Our Ref: MN/7451/App\_240621.  
24<sup>th</sup> June 2021

**Re: Planning application at 69-71 Church Road, Anerley, Crystal Palace, SE19 2TA  
Variation of Conditions 2 & 9 Application – Submitting of comparison drawings.**

In response to the invalidation letter dated 16<sup>th</sup> June for the Variation application for the project at 69-71 Church Road, Anerley, ref: DC/19/03203/RECON, I attach the following drawings with the original approved drawings overlaid in red, as requested, for your consideration.

Drawing No. **7451-PD-210** Revision

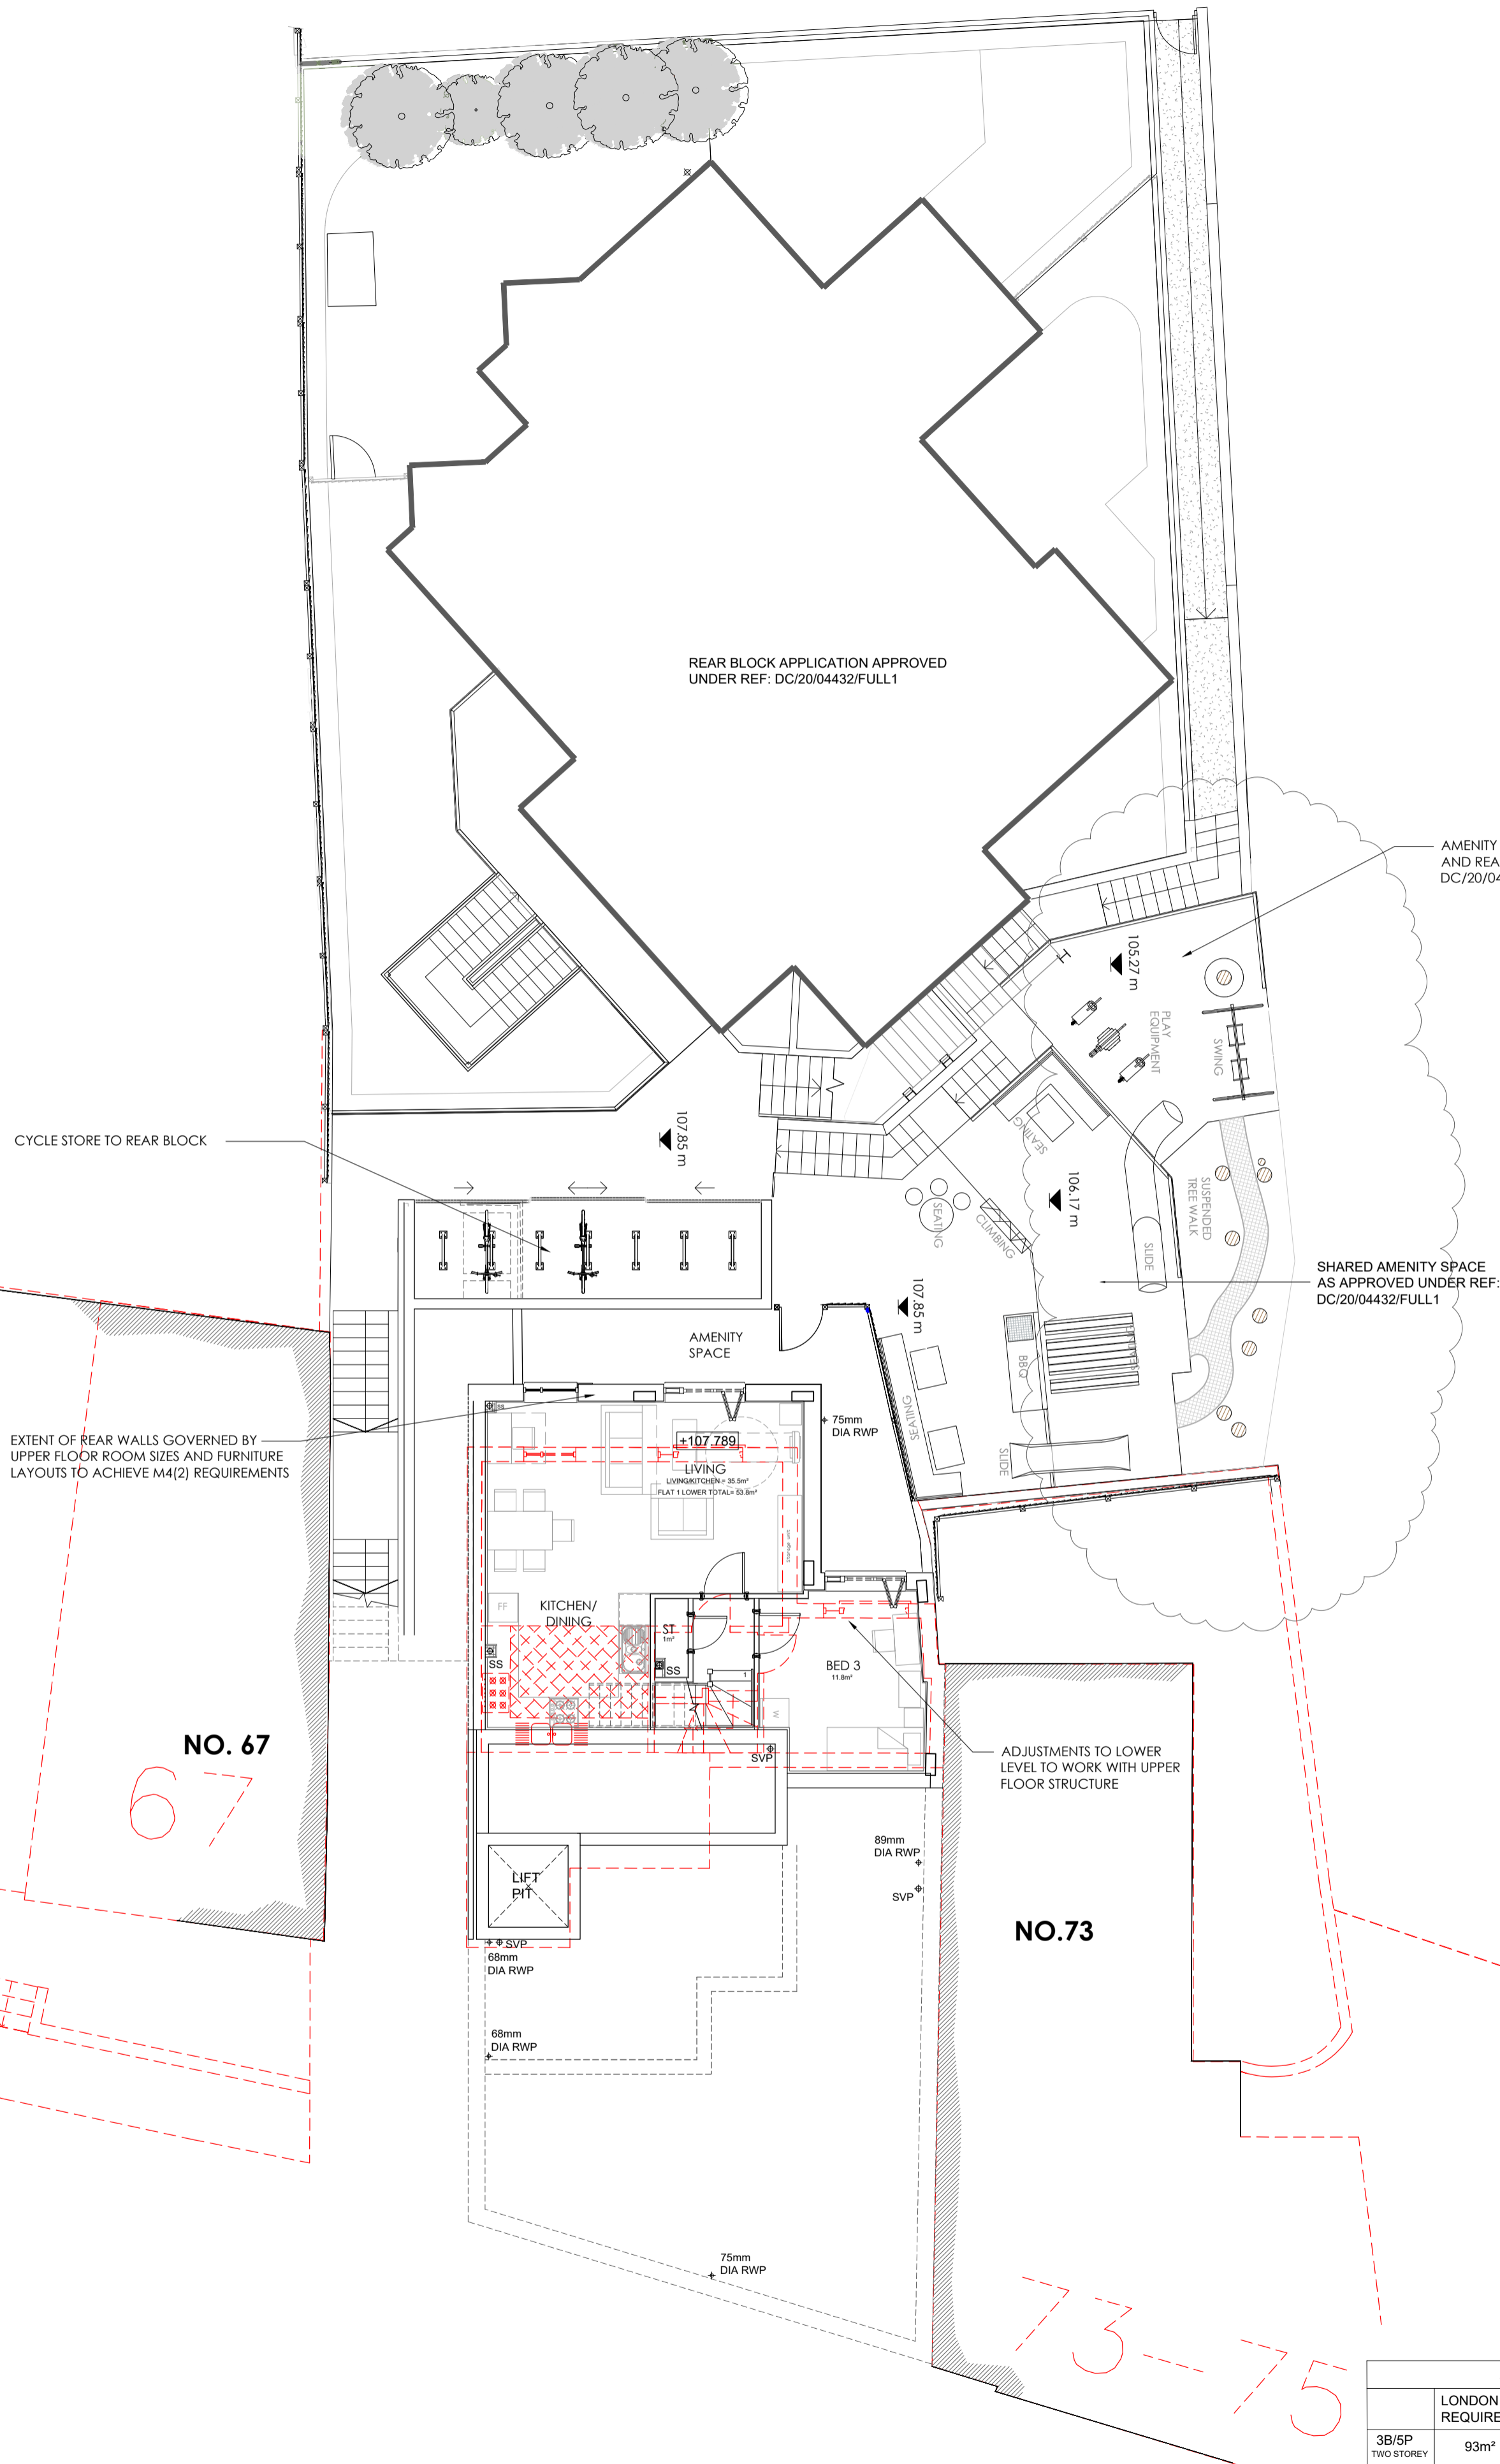
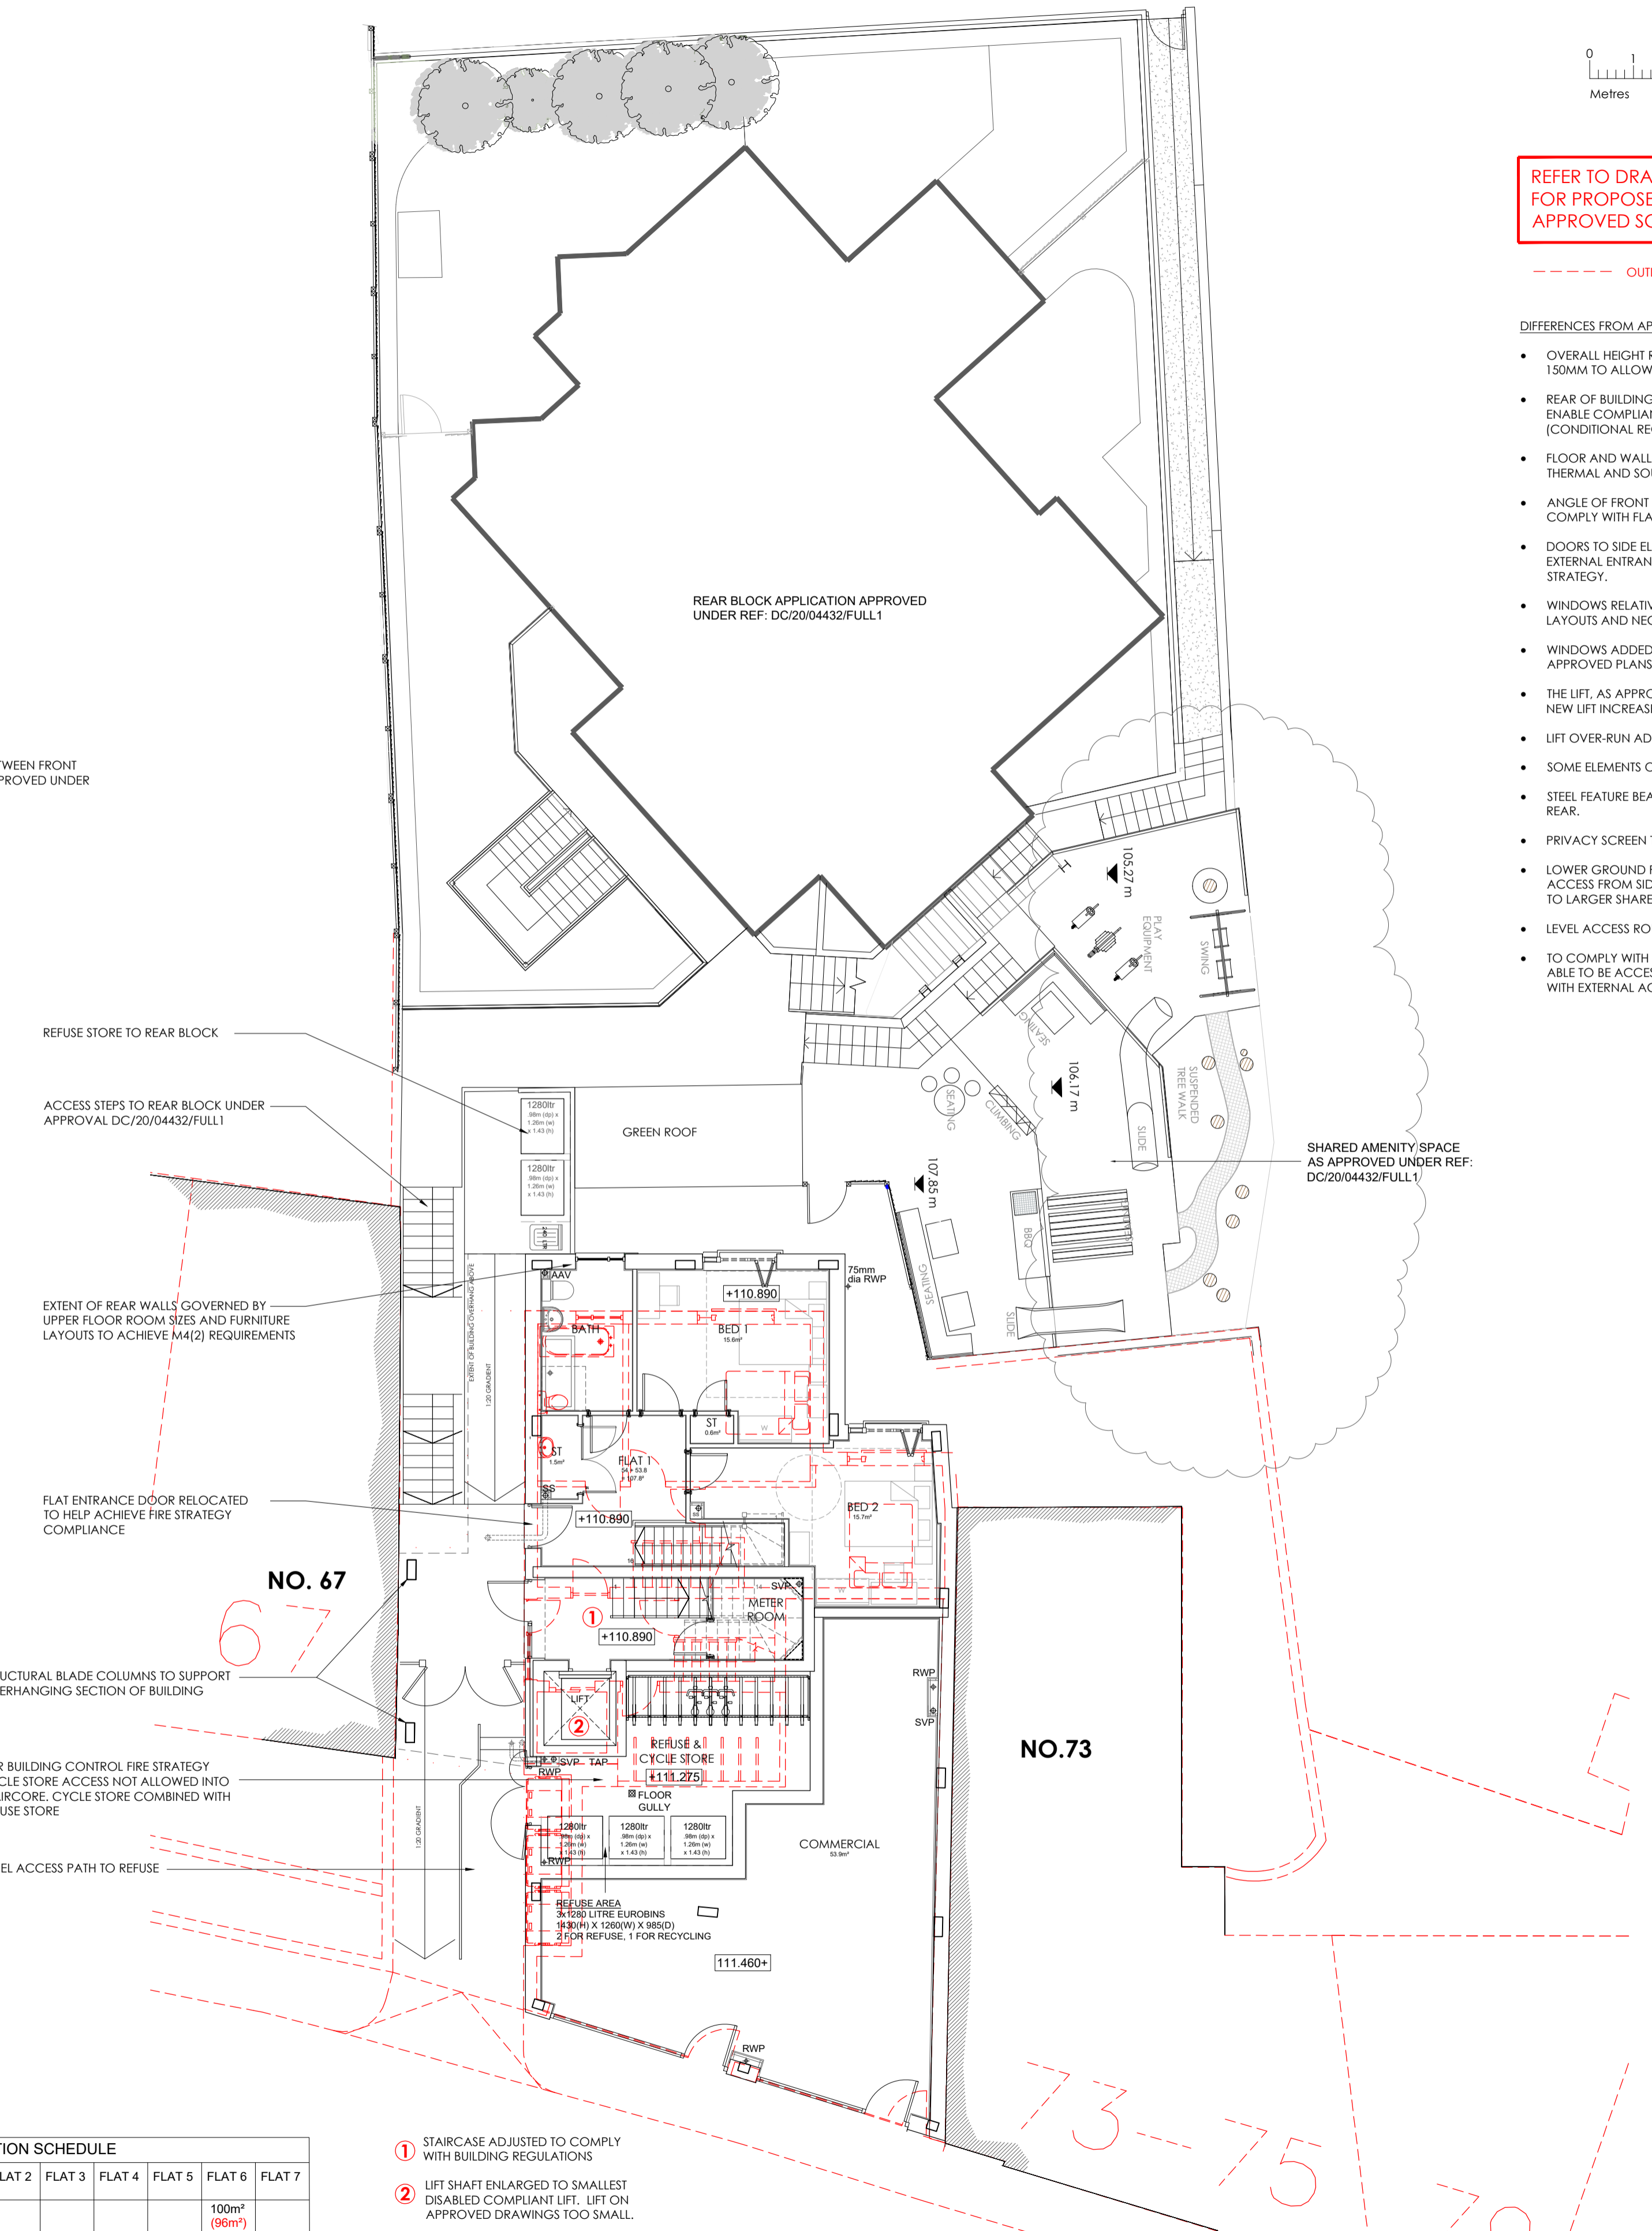
Drawing **7451-PD-210** Lower Ground & Ground Floor Plans

- The lift, as approved, was too small to comply with AD M4(2) requirements. New lift increased to achieve required car size for disabled users.
- Lift over-run added to elevation. Not indicated on approved elevations.

- Lower ground floor and ground floor levels lowered to enable primary access from side path. Also allows access from rear amenity space of flat 1 to larger shared amenity area. Window levels to rear adjusted to suit. Level adjustment also required to allow allowable sloped access to rear block's refuse store. Refuse store location approved under application DC/20/04432/FULL1.

- Level access route with guard rail to front block's refuse / cycle store.
- To comply with the fire strategy and Building Regulation fire safety regulations the cycle store was not able to be accessed from the staircore so has been combined with the refuse store with an external access.
